Tree Report Document Summary - Note Ryan Ringe has contacted John Kenney and was given an extension to submit his final report later because of a Hospitalization of his child

Tree Info: Greif, 5236 W Mercer Way Mercer Island

Note: I have reviewed the final plans, and will be recommending the following information in my final report

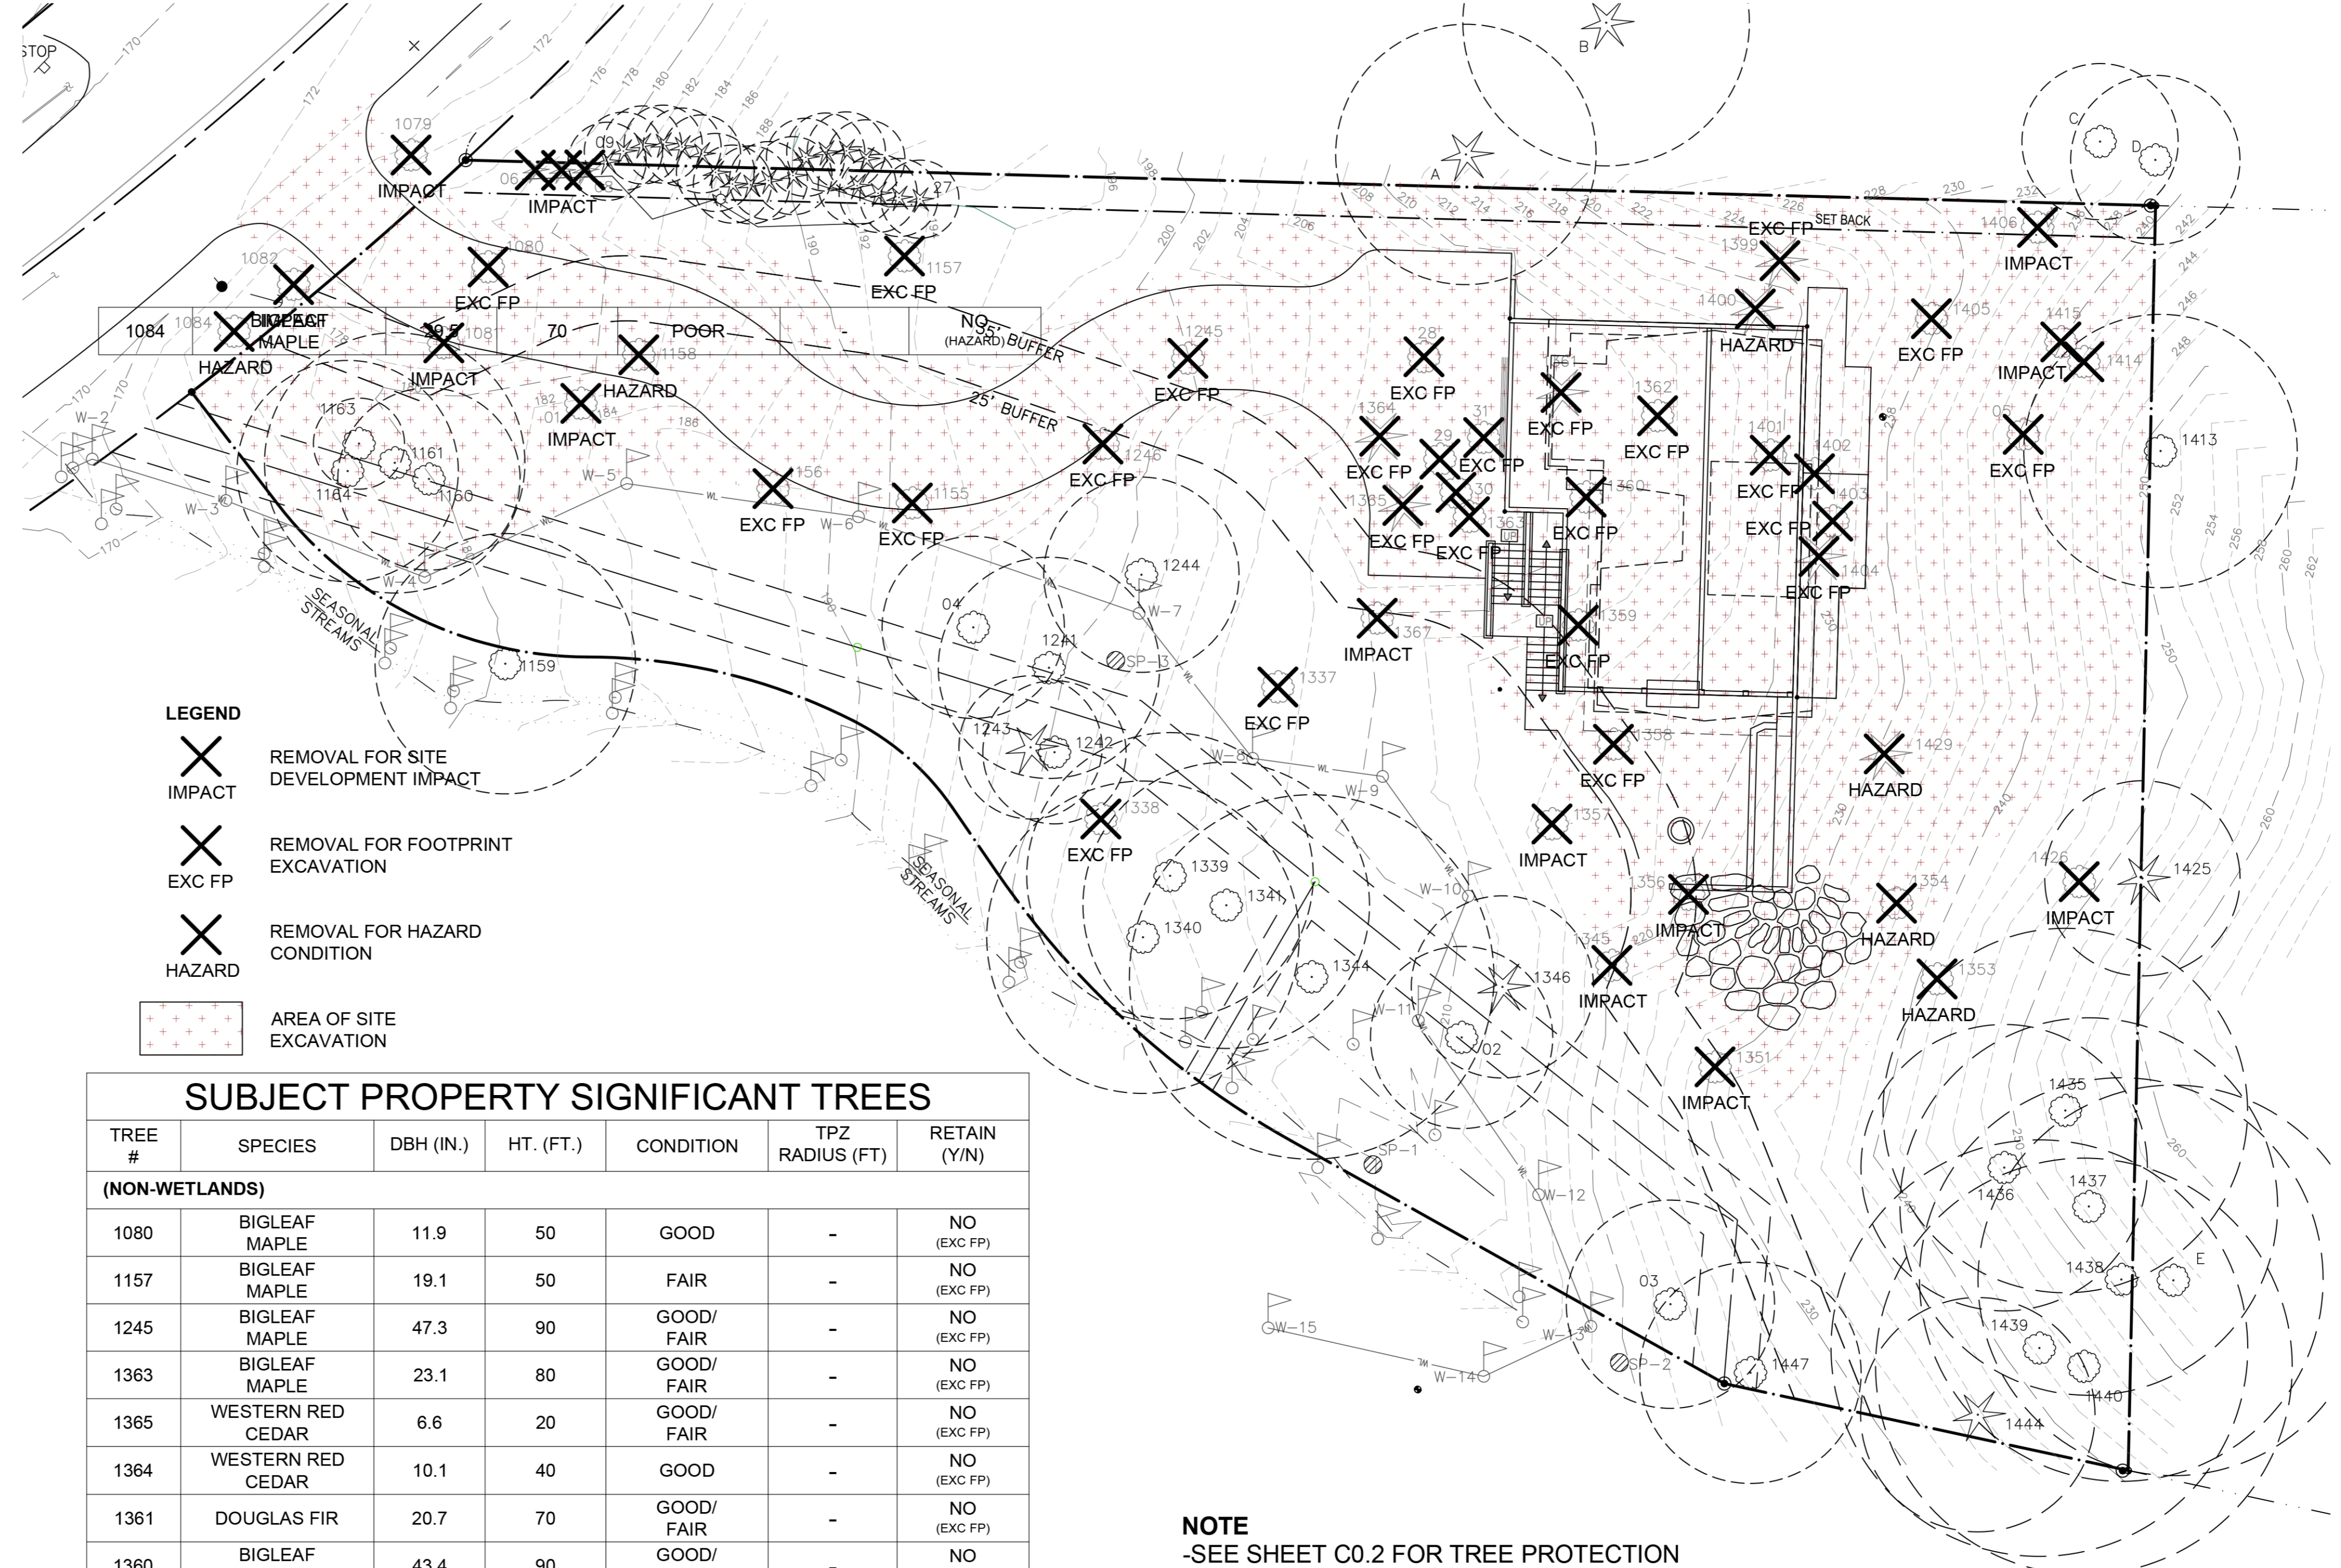
Trees #1444 and 1440 require their labels to be switched (1440 should be 1444 and vice versa).

Tree # 1158 (20" Bigleaf Maple) is located in the 35 ft. Buffer zone, and is a hazard tree. It should be removed before construction begins (or after construction entrance roads are made; with all of the large tree removals, a roadway will need to be established before removal).

Tree #1400 (10.5" Western Hemlock, Non-Wetlands tree) is in poor health and should be removed. It is also located within the proposed building footprint.

Tree #1429 (16" Western Hemlock, Non-Wetlands tree) has decay in the upper stem, and is questionable. It should be removed unless specifically desired for retention, in which case it would require aerial inspection/ coring.

Tree #1354 (47.3" Bigleaf Maple, Non-Wetlands tree) is a hazard tree and should be removed.

Tree #1353 (34.7" Bigleaf Maple, Non-Wetlands tree) is a hazard tree and should be removed.

Tree #1439 (41.1" Bigleaf Maple, Non-Wetlands tree) has a large dead stem that should be removed or shortened.

Tree #1084 (29.5" Bigleaf Maple in the R.O.W.) is a hazard tree, and should be removed/ snagged into wildlife tree; if the City desires to retain it they should be aware of it and monitor frequently).

Trees #1425, 1161, 1160, 1244, 1337, 1346, 04, A, B, C, D, and 1413 have disturbances within their driplines with additional protection notes; see below for notes and TPZ (Tree Protection Zone) radius.
